CITY OF ALBUQUERQUE

January 17, 2017

**RE: U-Haul at West Bluff
Atrisco Drive NW
Grading Plan and Drainage Report
Engineer's Stamp Date 12-5-2016 (File: H11D059)**

ENGINEER'S SEAL	WEST BLUFF BUSINESS CENTER	DRAWN BY DY
		DATE 1/30/17
	GRADING AND DRAINAGE PLAN	2016061-GRB
	 TIERRA WEST, LLC 5571 MIDWAY PARK PLACE NE ALBUQUERQUE, NM 87109 (505) 858-3100 www.tierrawestllc.com	SHEET # GR-1
RONALD R. BOHANNAN P.E. #7868		JOB # 2016061

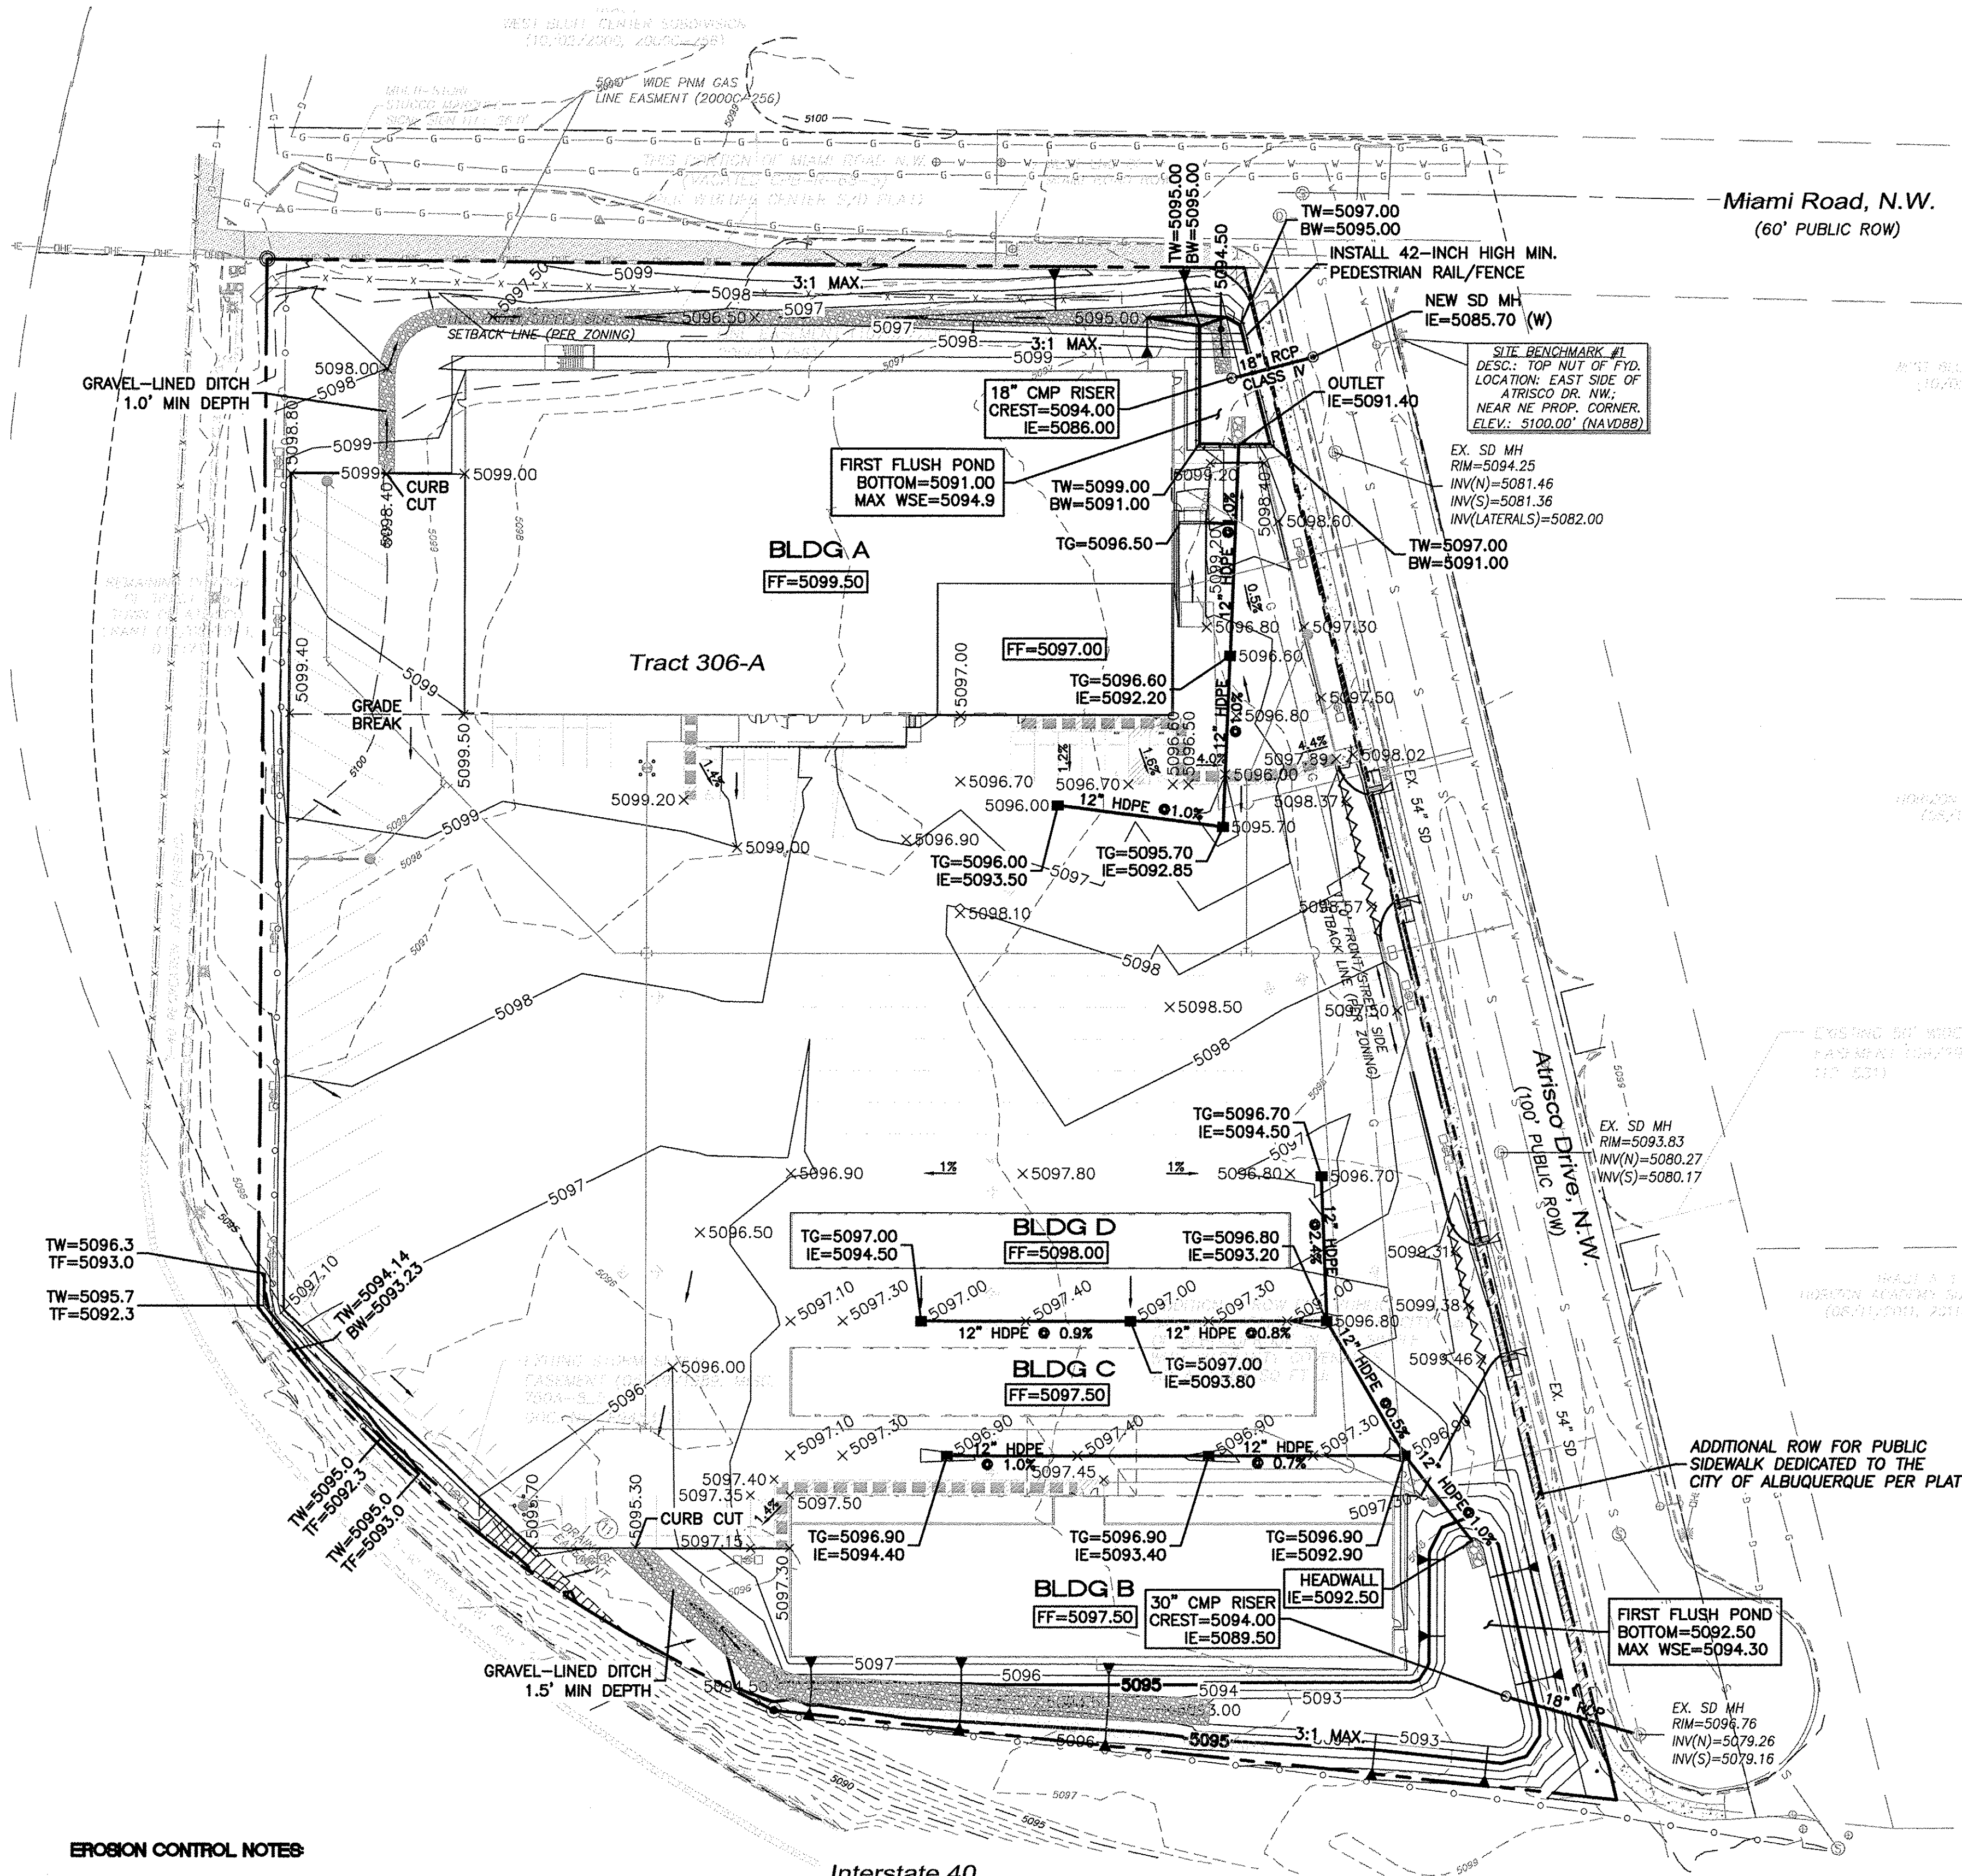
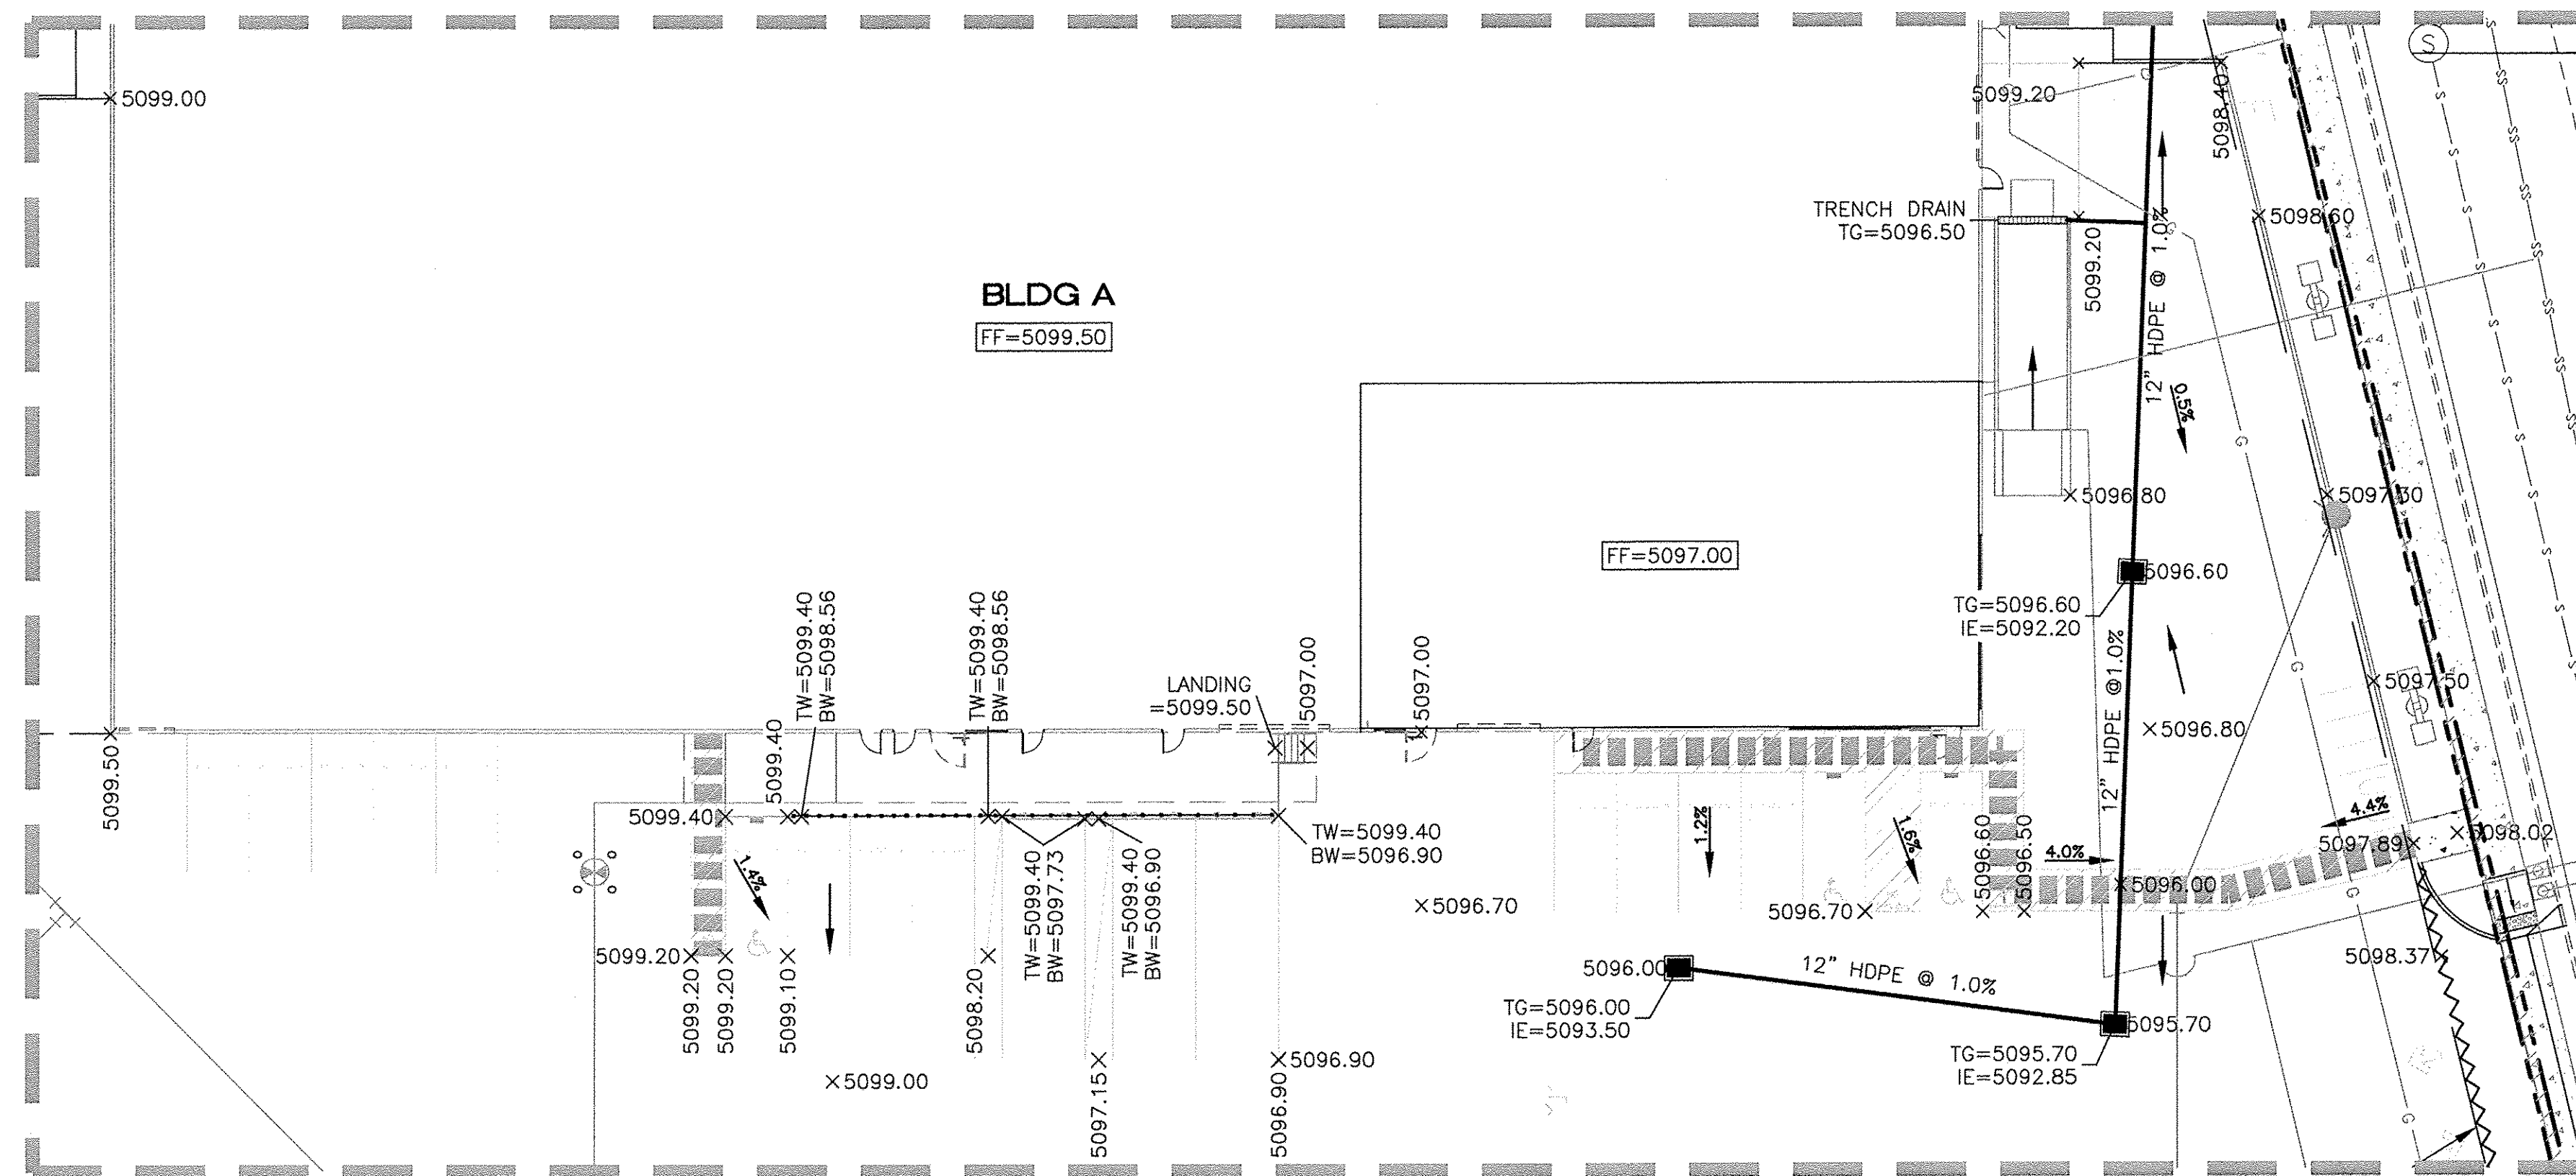
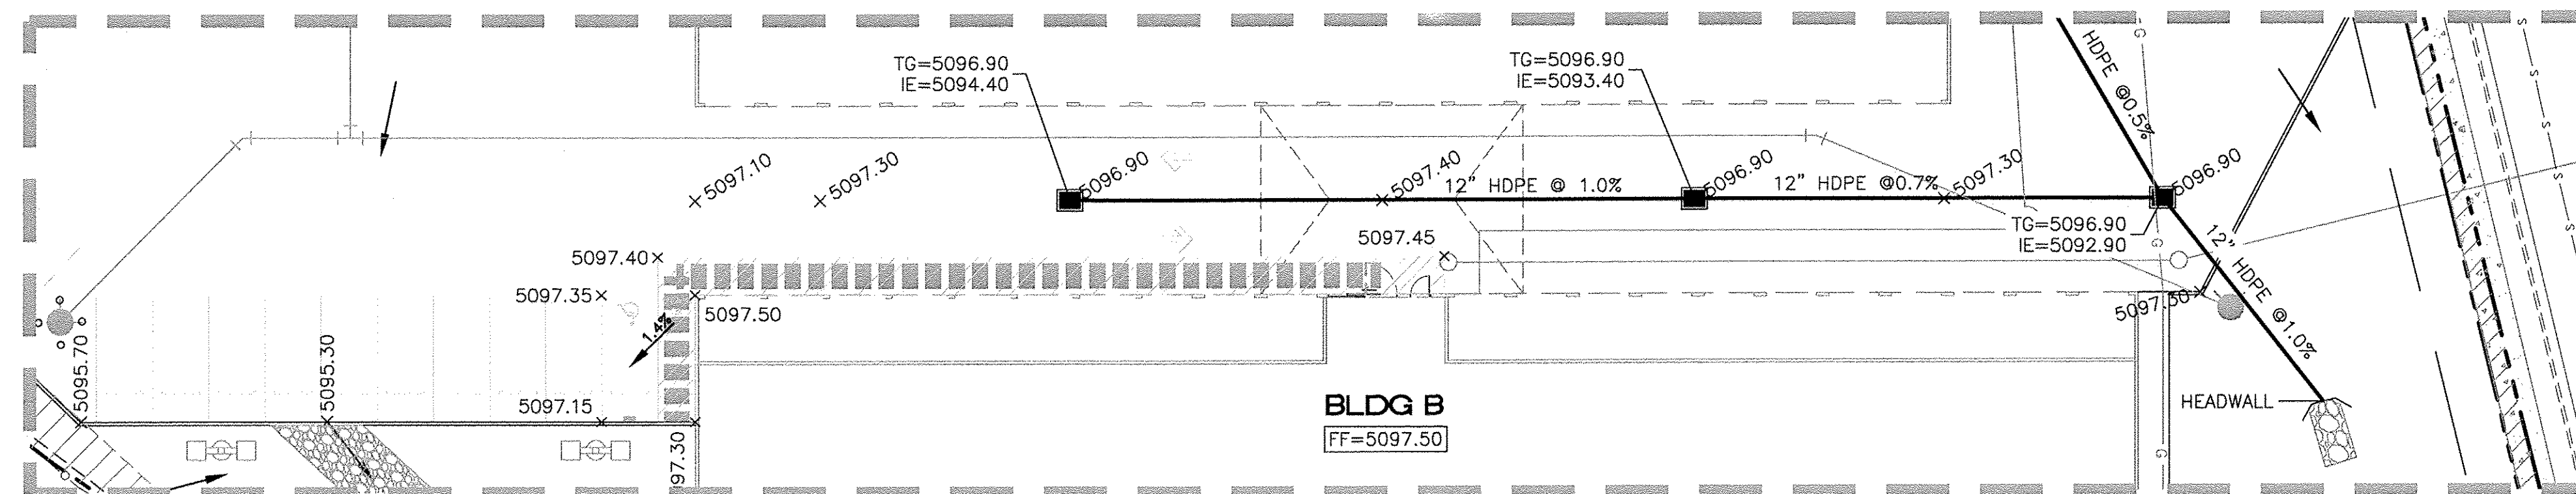
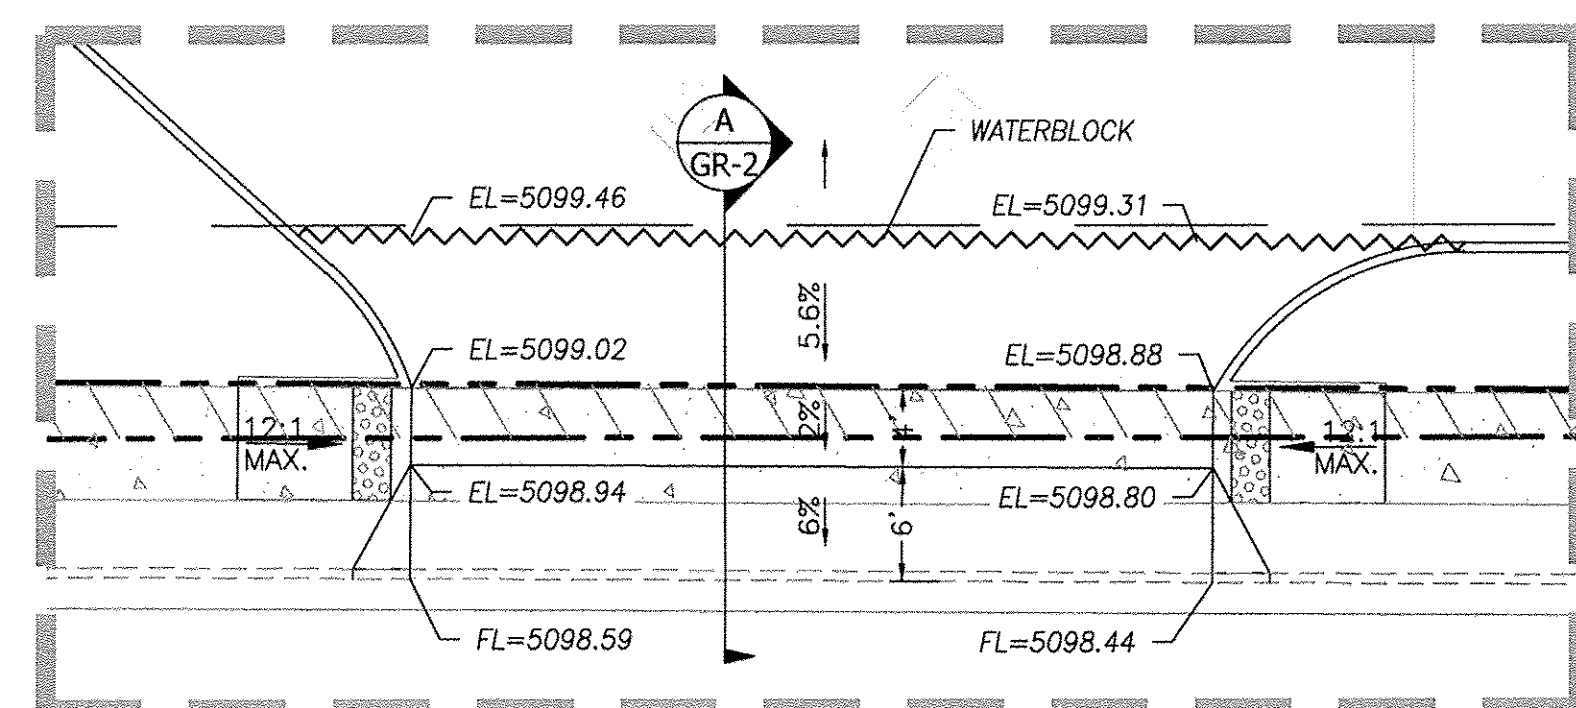
1. The North detention pond appears to be bounded by a CMU retaining wall as high as 8 feet in some places. This will need to be enclosed with a fence at least 42 inches high.

2. Call out Class IV RCP for the north detention pond outfall pipe under the retaining wall.
3. Additional detail is required for the two curb cuts and their associated water blocks to ensure ADA compliance for pedestrian traffic along Atrisco. Provide section views at these locations, including flow line elevation, slope, and waterblock elevations.

4. Project Benchmark and Vertical Datum is missing from the sheets. The Drainage Management Plan addresses the NGVD29 to NAVD88 shift, but sheets need this information as well.

5. A portion of the sidewalk is within the parcel property, if there is no existing sidewalk easement, one will need to be provided.
6. Verify that the two drop inlets are capable of handling twice the 100-yr flow at the sump on Atrisco. It appears this location has a single-C and double-C on each side of the road. If these inlets are insufficient, additional inlets will be needed on the new lateral from the north pond to prevent flows from spilling over into the north pond.
